2191002

Response to Request for Information for Eastern Creek Quarter - Lot 3 Concept Plan (SSD-10457)

INTERSECTION LAYOUT - TURNING PATHS
SCALE: 1:250@A1

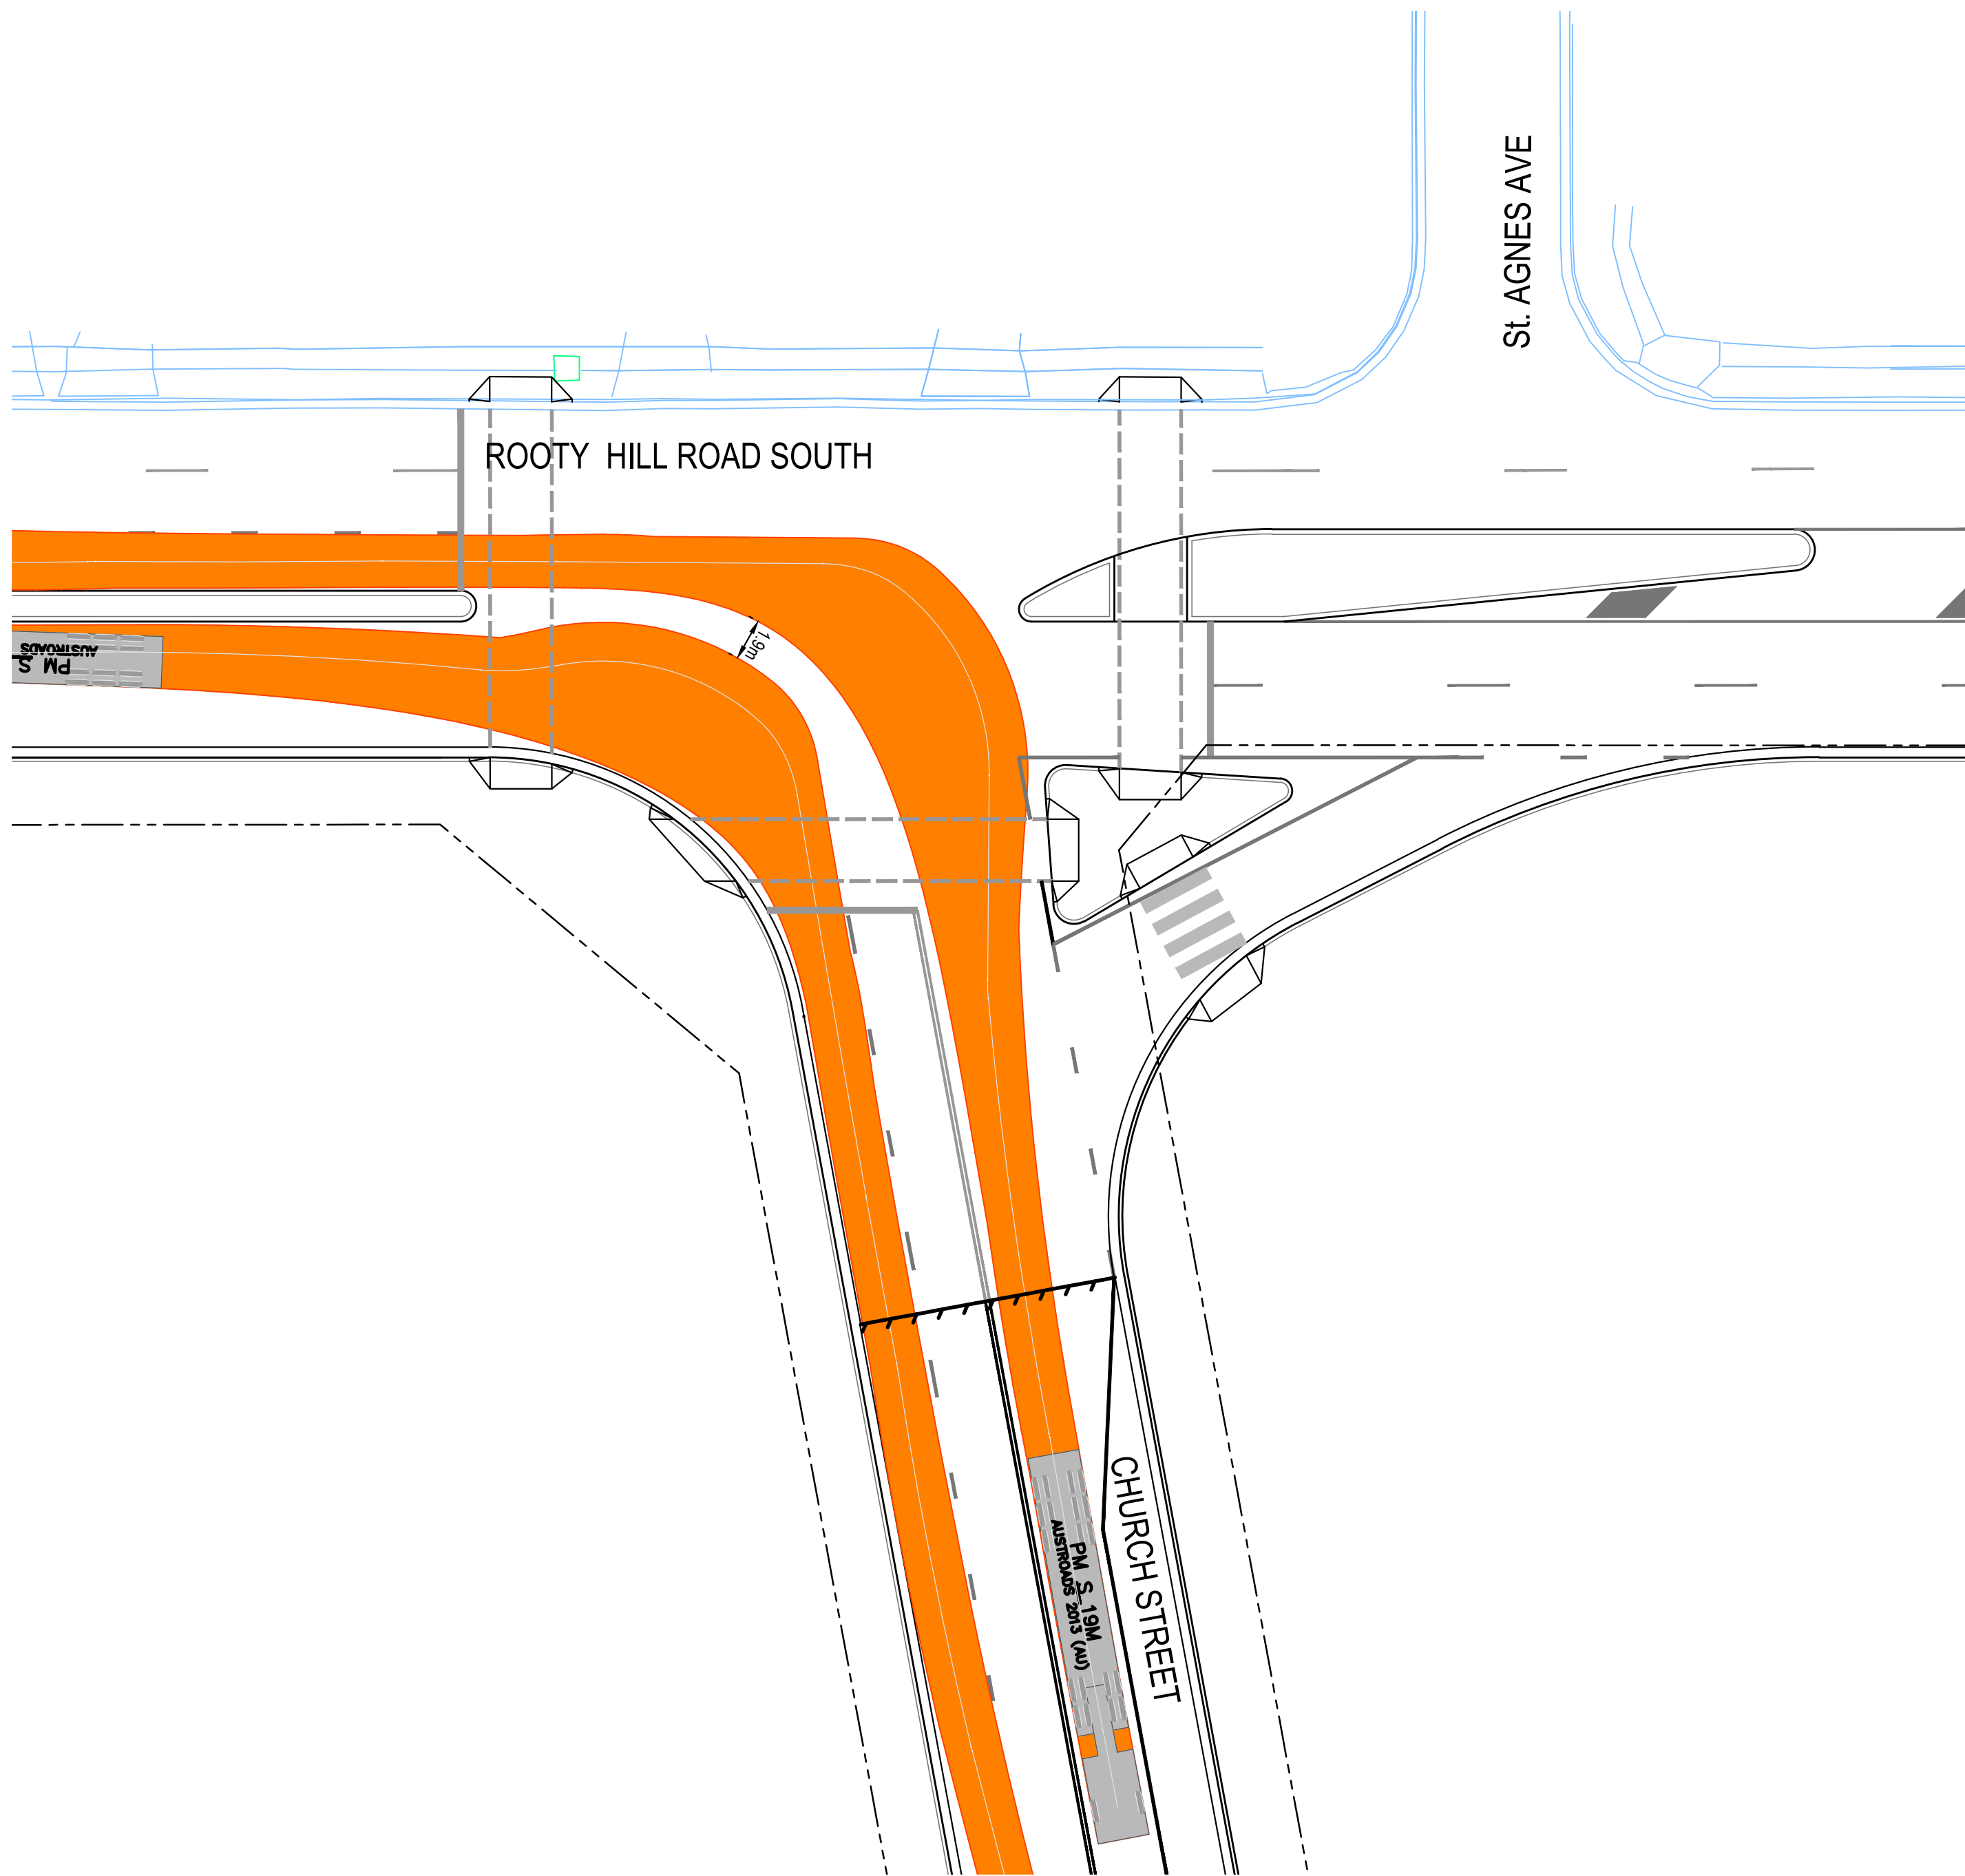
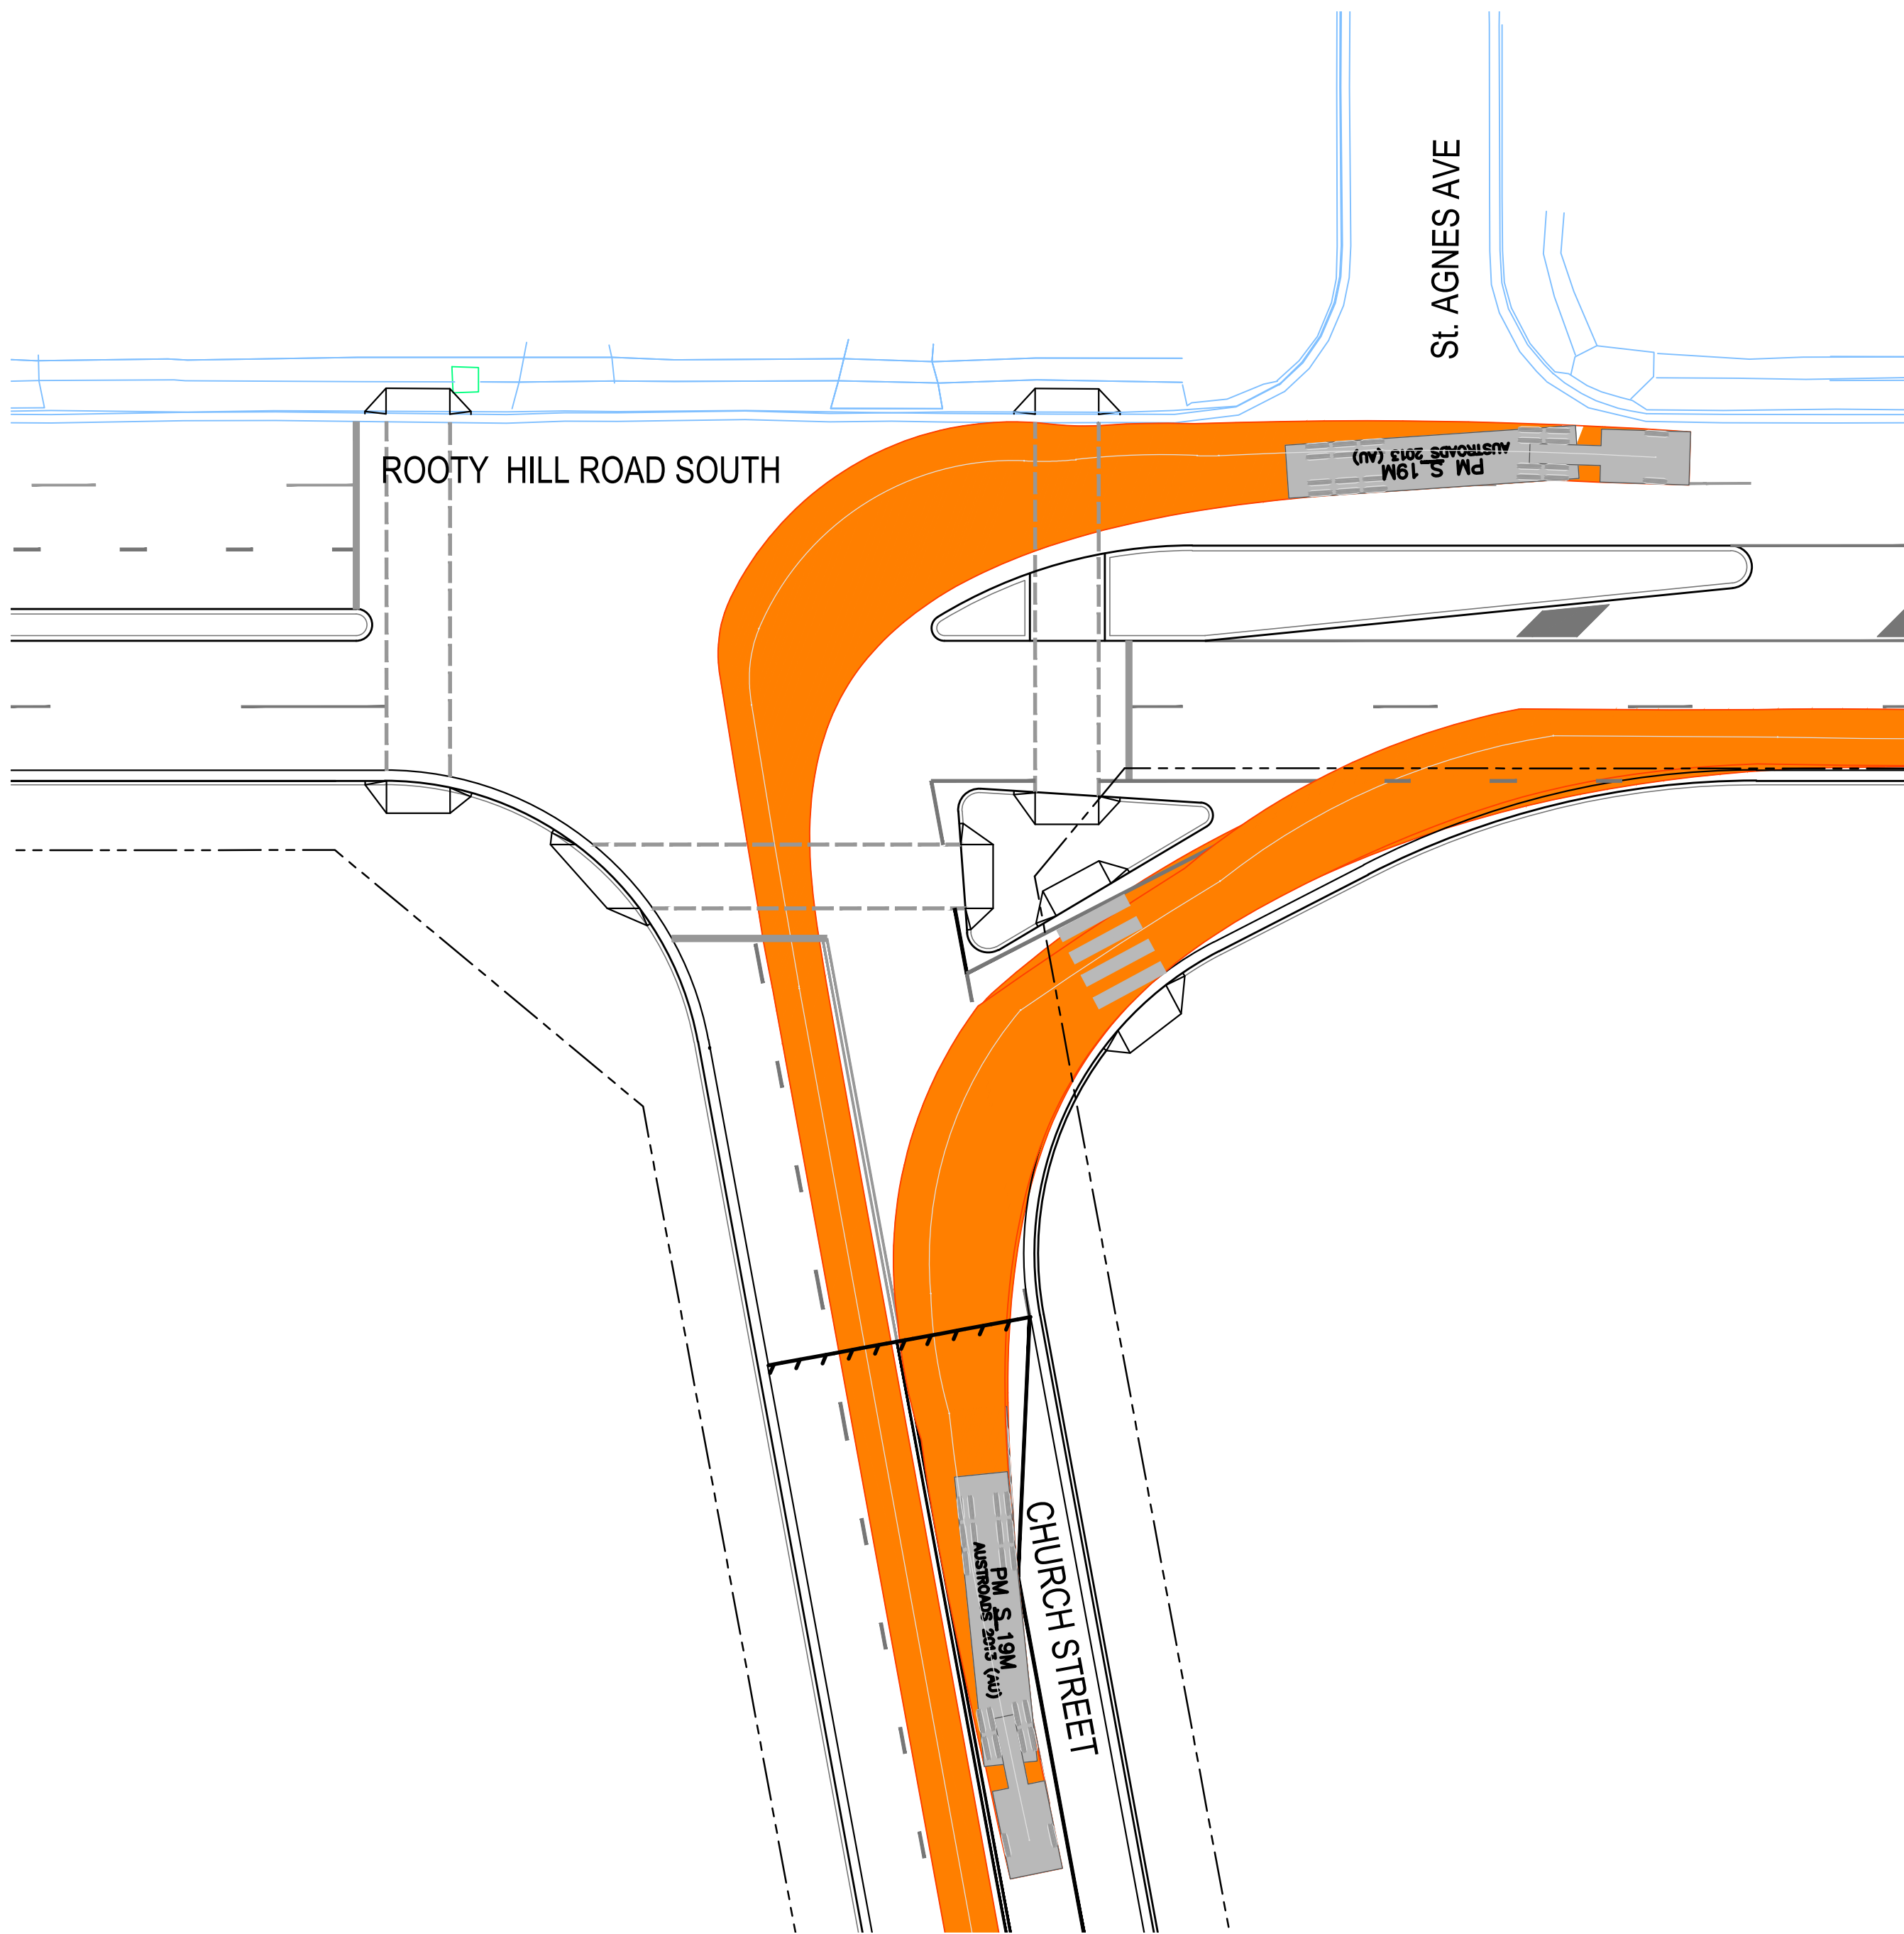
Matter raised	Response
TfNSW Submission	
We require additional information in response to the items raised by TfNSW in its letter dated 7 September 2021. This should include consideration of any alternative options which would enable access to the proposed outlet centre while managing/mitigating impacts on Rooty Hill Road South and affected local streets, in consultation with TfNSW and Council as required.	<p>Since receiving their initial submission, ongoing consultation has occurred with TfNSW regarding the necessary intersection upgrades in accordance with Council's preferred concept design involving traffic signals. As part of this consultation, a preliminary response to the submission was sent to TfNSW on 18 October 2021 which included a revised intersection concept design and a meeting was subsequently held on 21 October 2021 to discuss.</p> <p>At this meeting, it was acknowledged that the design principles and response were generally consistent with TfNSW's previous feedback and it was agreed that the intersection concept design would be updated to show:</p> <ul style="list-style-type: none"> • A single pedestrian crossing; • A left turn high angle slip lane; • Median extended to prohibit right hand turns to/from St Anges Ave and Minchinbury Street. <p>CBRK has since provided the attached response to TfNSW (Attachment A) which addresses these matters.</p> <p>It is noted that the 3.5m wide road reserve for Church Street south shown on the revised concept intersection is already accommodated by the proposed plan of subdivision accompanying this application. As outlined in the previous RFI response (dated 16 October 2021), and as shown on the current intersection concept, works to Morreau Reserve would be required to accommodate the left turn slip lane to TfNSW standards. The final design of this intersection will</p>

Matter raised	Response
	seek to minimise the extent of works required in this area and this will be addressed as part of a future WAD process for the delivery of the intersection upgrades.
Economic Impacts	
Clarify the term 'Urban Renewal Precincts' in the addendum economic statement.	The term 'Urban Renewal Precincts' has been taken from Blacktown City Council's Local Strategic Planning Statement (LSPS) in response to Council's original submission which requested that the economic impact assessment reflect Council's hierarchy of centres. Accordingly, the assessed localities were grouped into centres corresponding with Council's identified centres in their LSPS.
Detail how the 'balance of centre' groupings for strategic centres and key centres align with the economic impact assessment provided with the EIS.	The impact analysis in the Macroplan EIA focused on the key shopping centres in the identified strategic and key centres, as the potential impacts from Eastern Creek Quarter would mostly fall on these facilities. Uses in the 'balance of centre' were not specifically covered in the impact analysis provided in the EIA. The Economic Advice letter addresses the potential impacts on the 'balance of centre' uses for completeness, and confirms that the impacts on the 'balance of centre' uses, excluding the major shopping centre, would be very minor.
